PROJECT TITLE: COMMUNICATIONS CENTER ZONE ATLAS/DRNG. FILE #: L-8/D11A1

Re: Communications Center (L8-D11A1)

**RE: COMMUNICATIONS CENTER (L8-D11A1). UPDATED GRADING AND DRAINAGE  
PLAN FOR BUILDING PERMIT APPROVAL. ENGINEER'S STAMP DATED  
AUGUST 28, 1997.**

COMMUNICATIONS CENTER		
NOV 03 1997		
HYDROLOGY SECTION		
DATE:	DRN BY:	VHQA PROJ. #237
FILE:	CHK BY:	PLOT:
		SHEET OF

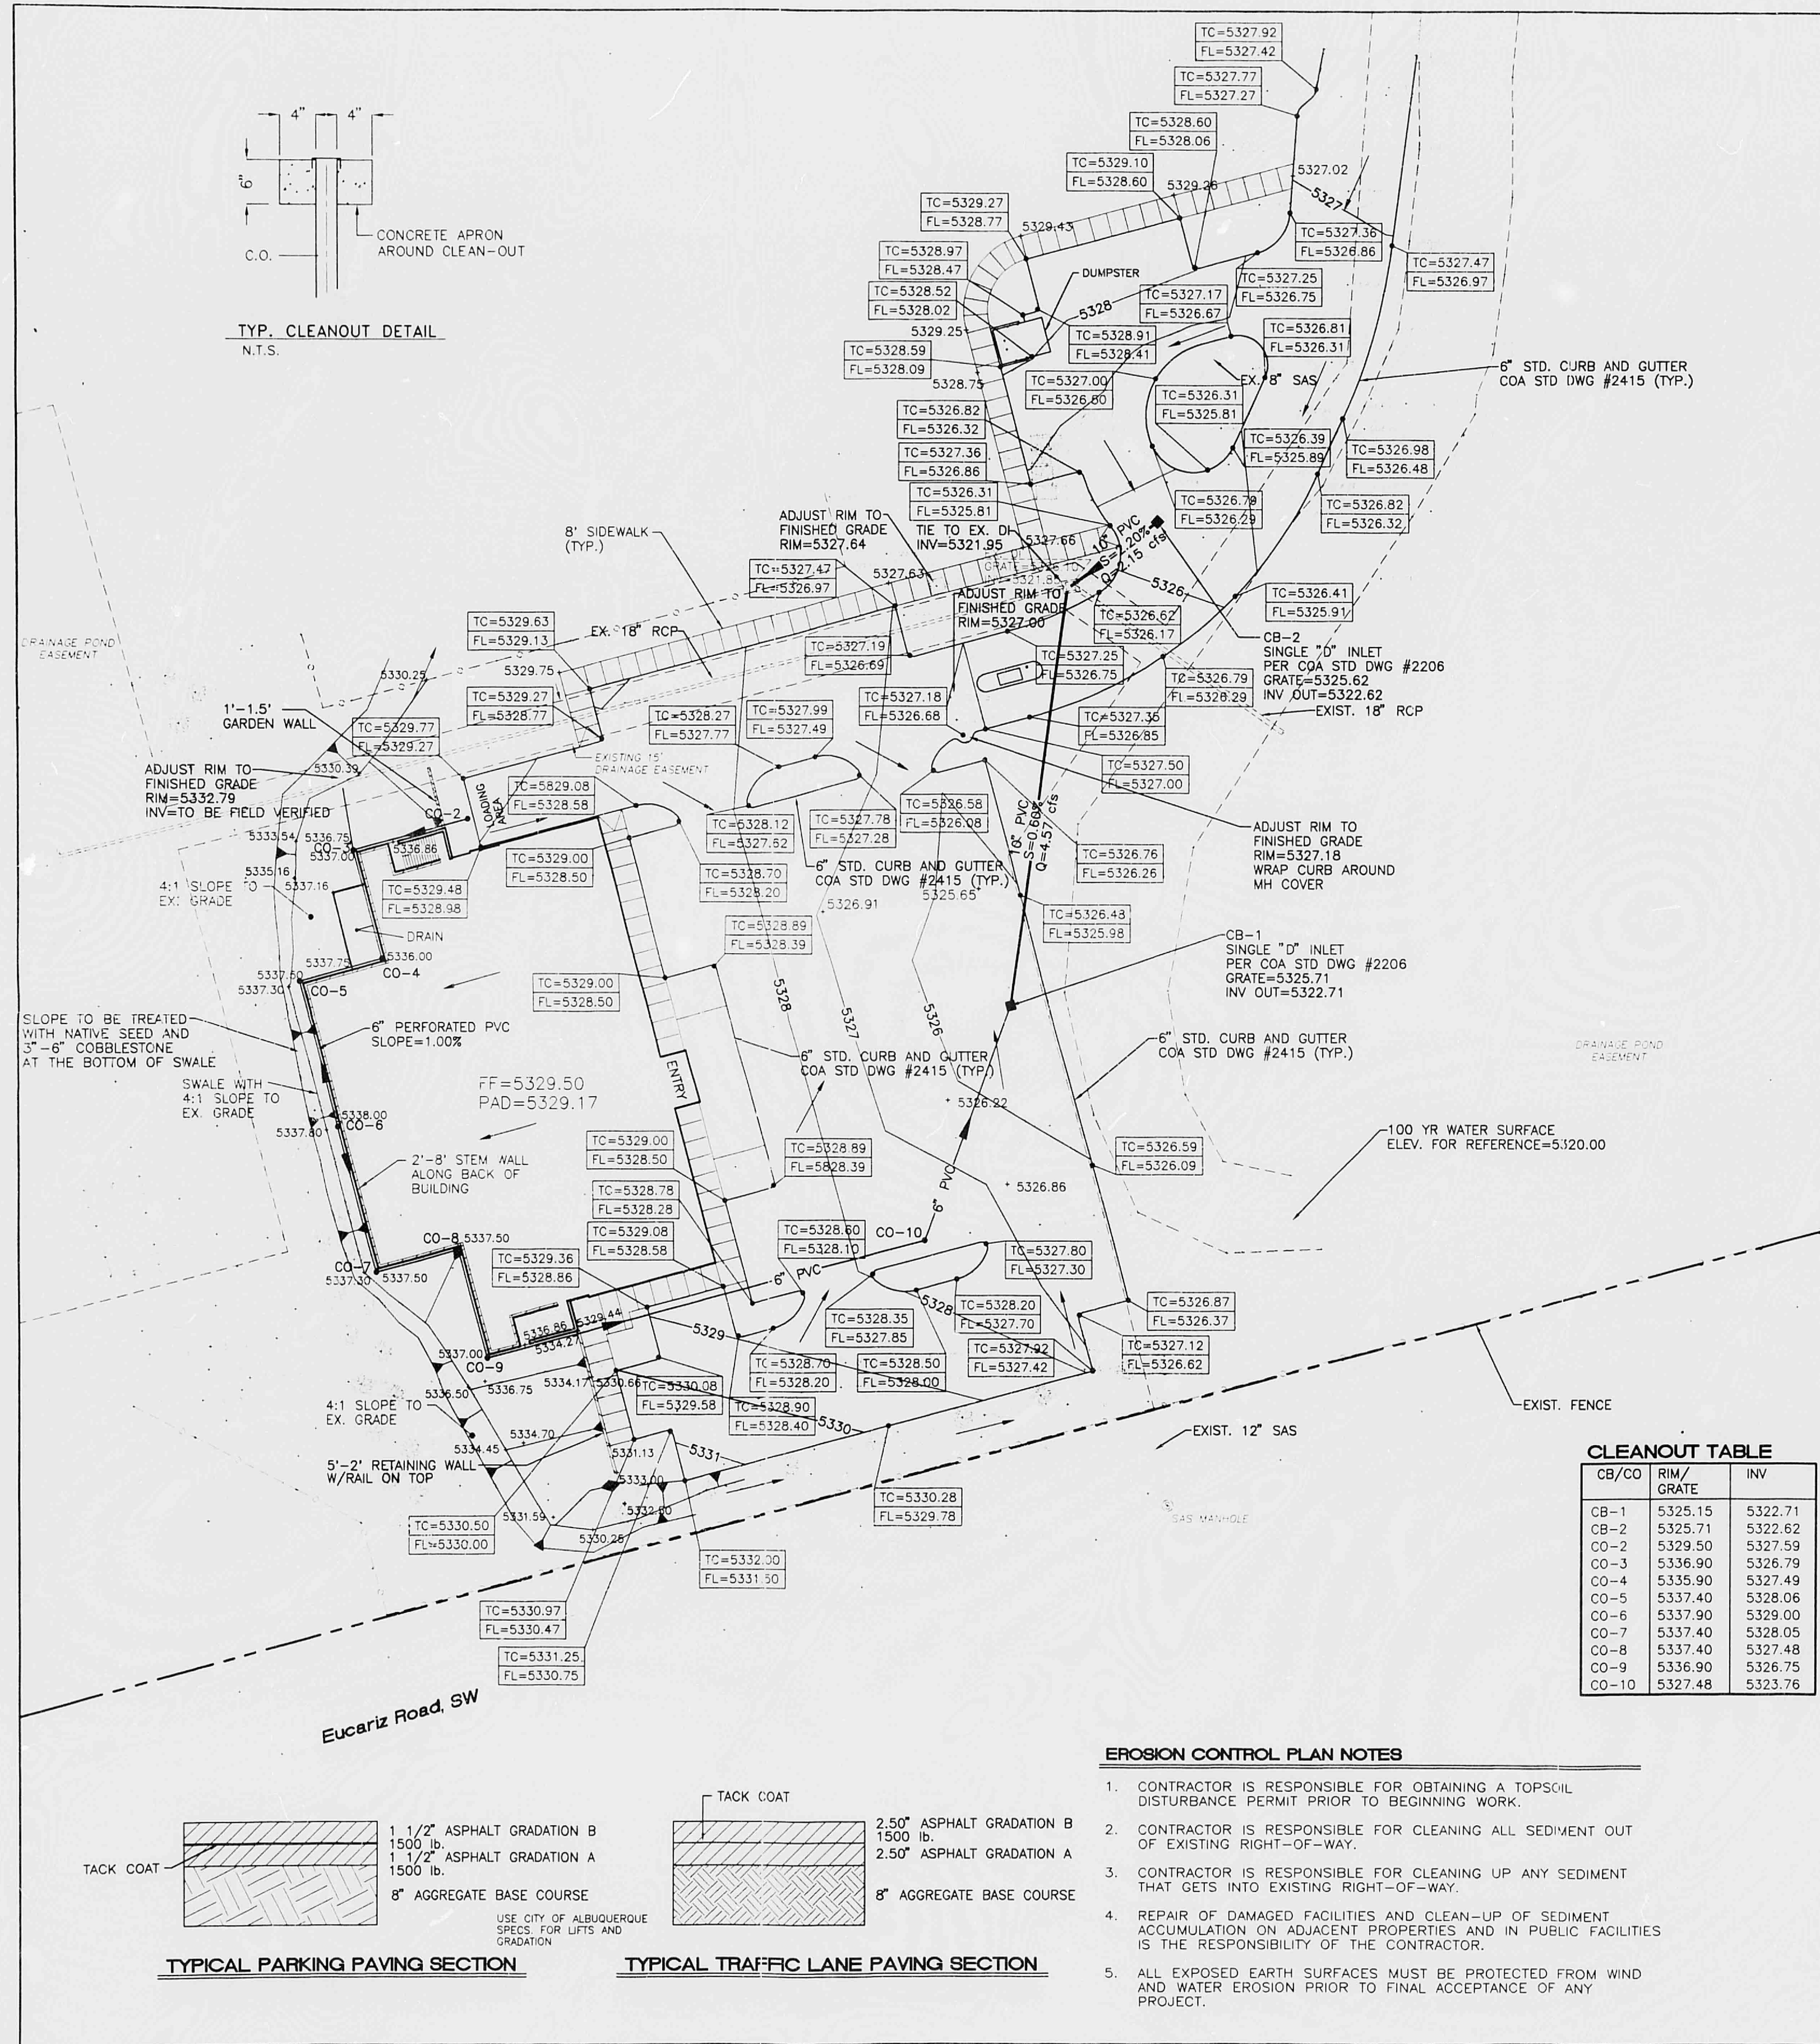
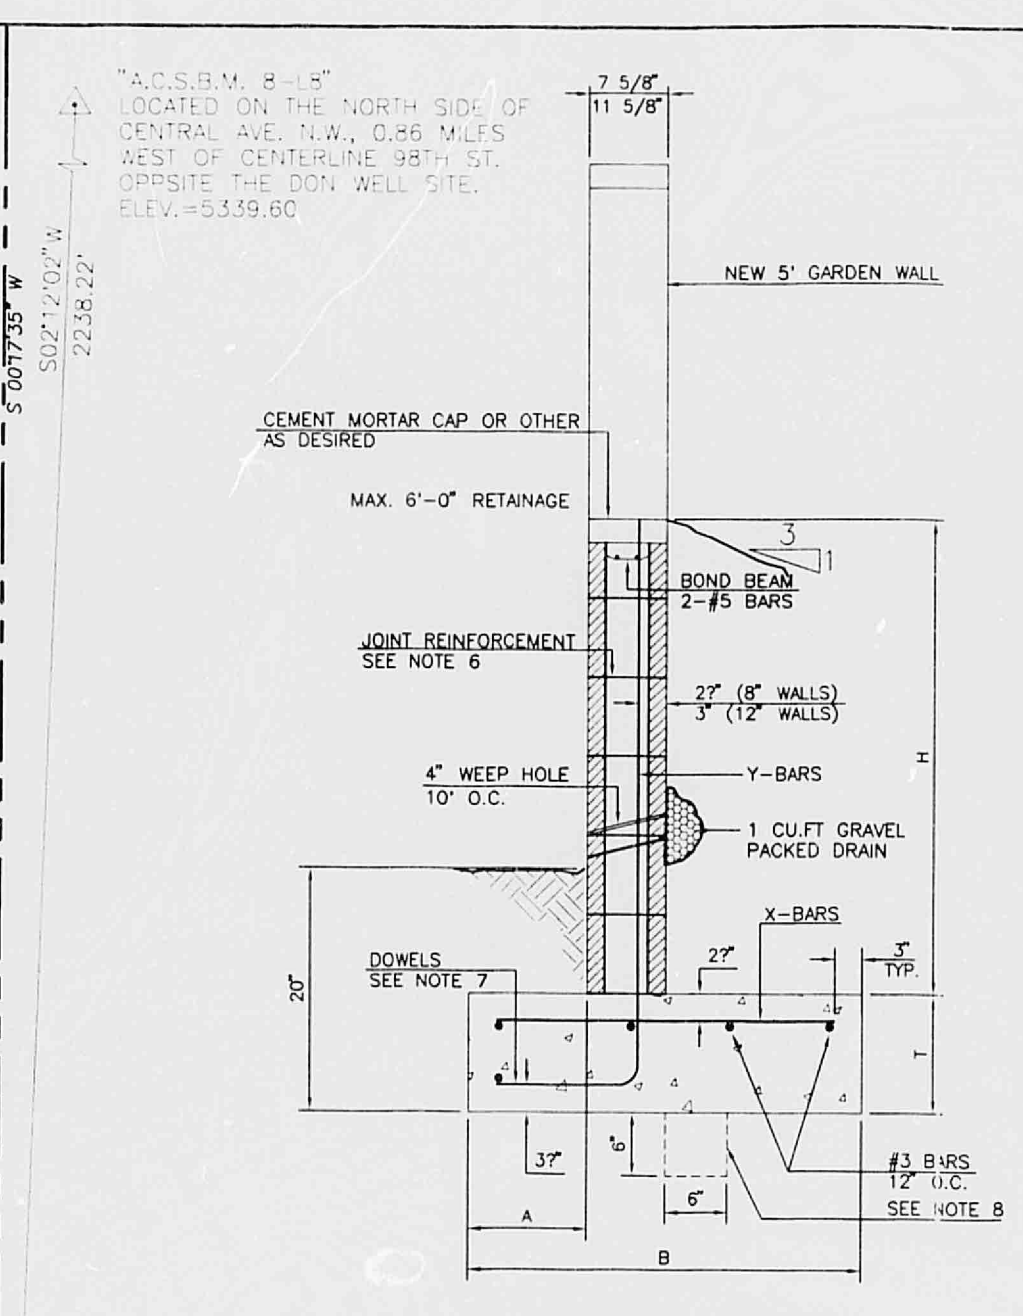
1. Label all storm drain pipe (new and existing).
2. Label all inlets, cleanouts, and manholes (new and existing).
3. Use a minimum of 6-inch storm drain pipe.
4. The master plan indicates that Pond #2 is actually a detention facility with a very small release rate.
5. This project is located out of City limits. The project should be reviewed and accepted by Bernalillo County.

1. All the existing and new storm drains pipes have been labeled.
2. All the existing and new inlets, cleanouts, and manholes have been labeled.
3. The 4" storm drain pipe has been upgraded to 8" at the request of DRC.
4. Pond #2 is not a retention pond but a detention pond.
5. Although the project is out of the City limits, Bernalillo County has elected to have the City review the project due to the fact that the project will be owned and maintained by the City of Albuquerque.
